Your Ref: ACP-323860-25

Our Ref: SID-CW-2025-032

Proposed Strategic Infrastructure Development (SID): 10 year planning permission for a 220kV AIS/ 220kV GIS substation OR a 110kV electricity substation, associated 220kV or 110kV underground grid connection and ancillary works located in the townlands of Ballyloo, Knockbower, Linkardstown, Kilballyhue, Graiguenspiddoge, Castletown, Moyle Big, Leigh or Ballybeg, Kellistown West and Kellistown East, County Carlow

Outlined below are heritage-related observations/recommendations of the Department under the stated heading(s).

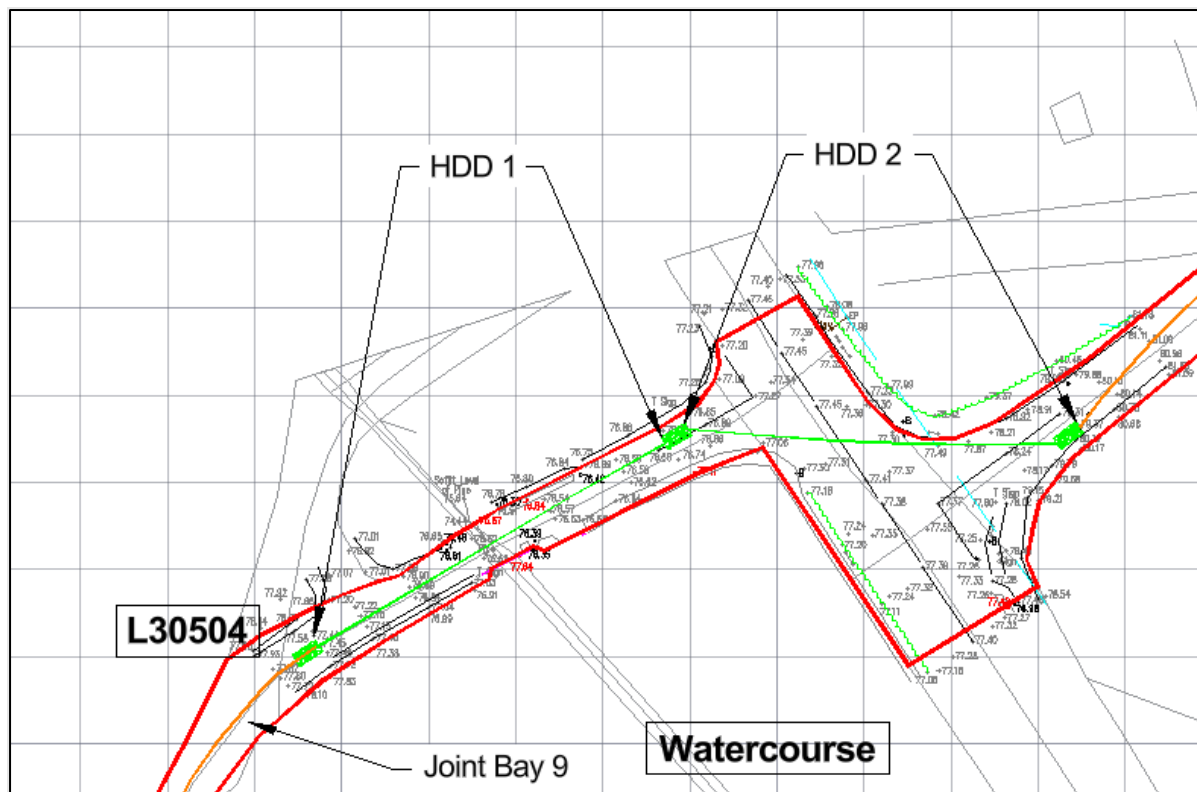
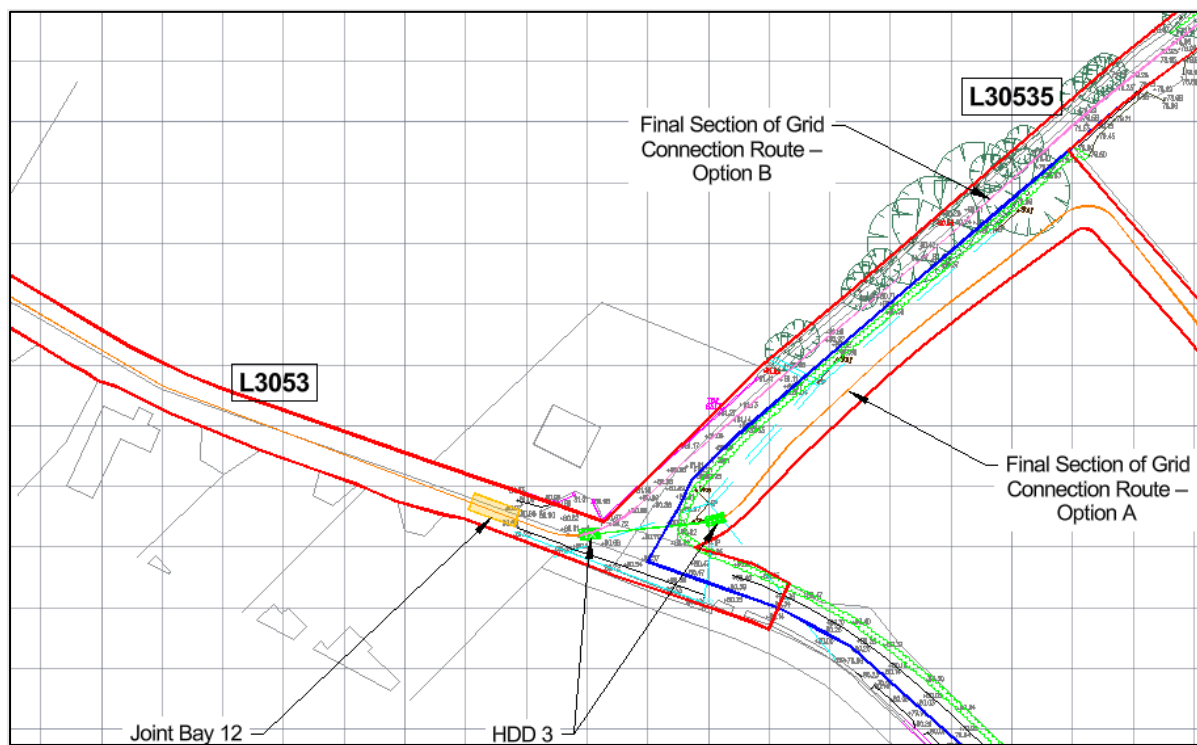
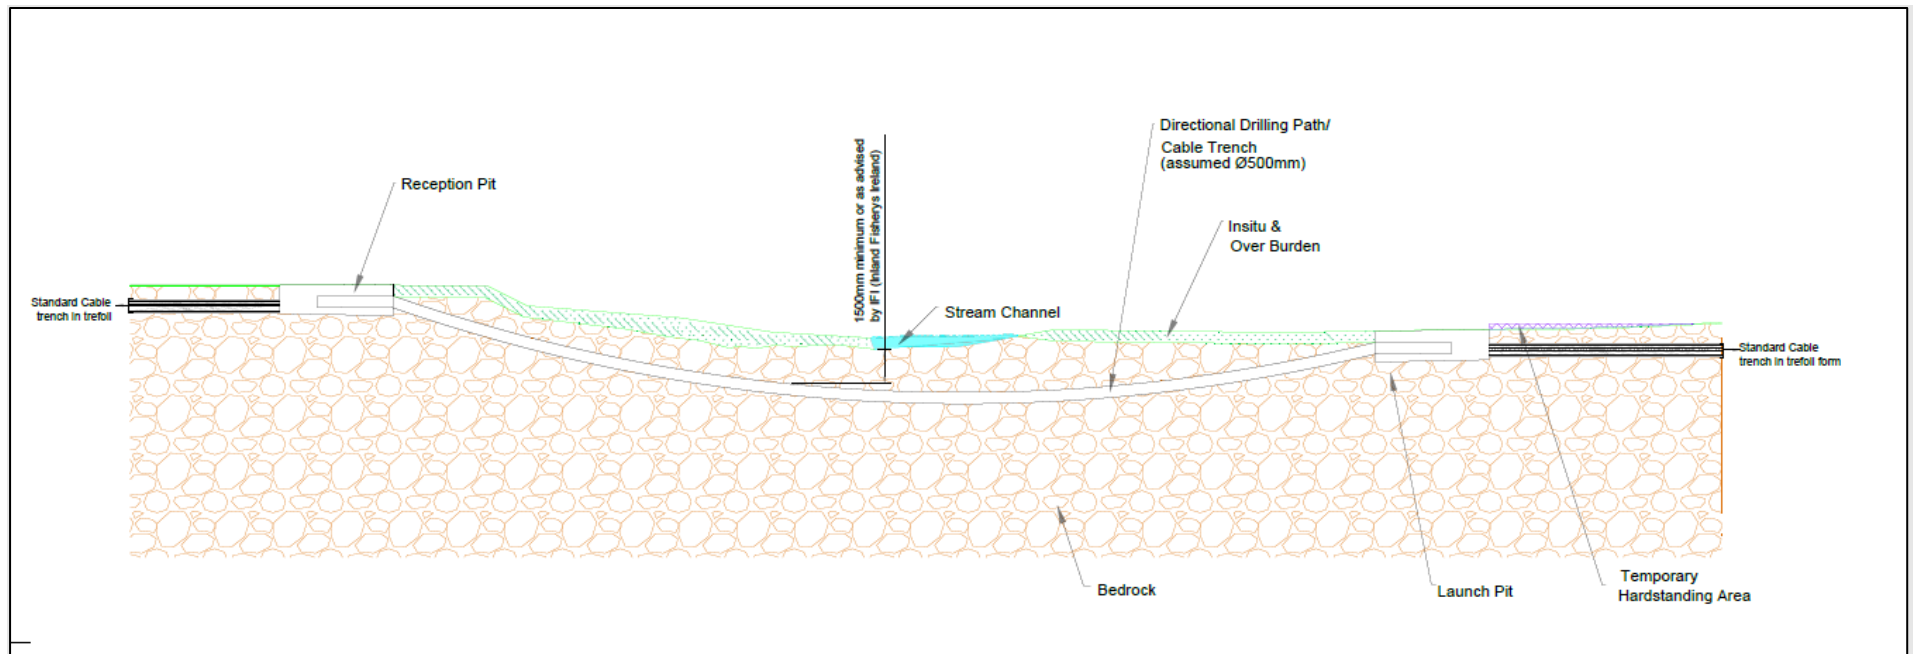
- 4. For any watercourses where cable ducting cannot be inserted using trenchless methods then the developer shall commission an Underwater Archaeological Impact Assessment (UAIA), which shall include the following:**

- a. A desktop assessment that addresses the underwater cultural heritage (including wrecks, archaeological objects, built heritage, riverine heritage and industrial heritage) of all waterway crossings where works are proposed. The assessment shall**

- include a full inventory, mapping and survey (photographic, descriptive, photogrammetric, as appropriate) of underwater cultural heritage features and structures and archaeological objects identified by desk study research, fieldwork, cartographic analysis, historical research and prior archaeological investigations.

- b. The UAIA shall include a dive/wade assessment (consent/licensed as required under the National Monuments Acts), accompanied by a hand-held metal detection survey, centred on (but not confined to) any area(s) where in-stream works are proposed.

- c. Having completed the above-described works, the archaeologist shall submit a final written report to the National Monuments Service of the Department describing the results of the UAIA. The report shall include a comprehensive Archaeological Impact Statement (AIS). No construction works shall commence until after the UAIA has been submitted and reviewed. All recommendations will require the agreement of the National Monuments Service of the Department prior to construction commencing.
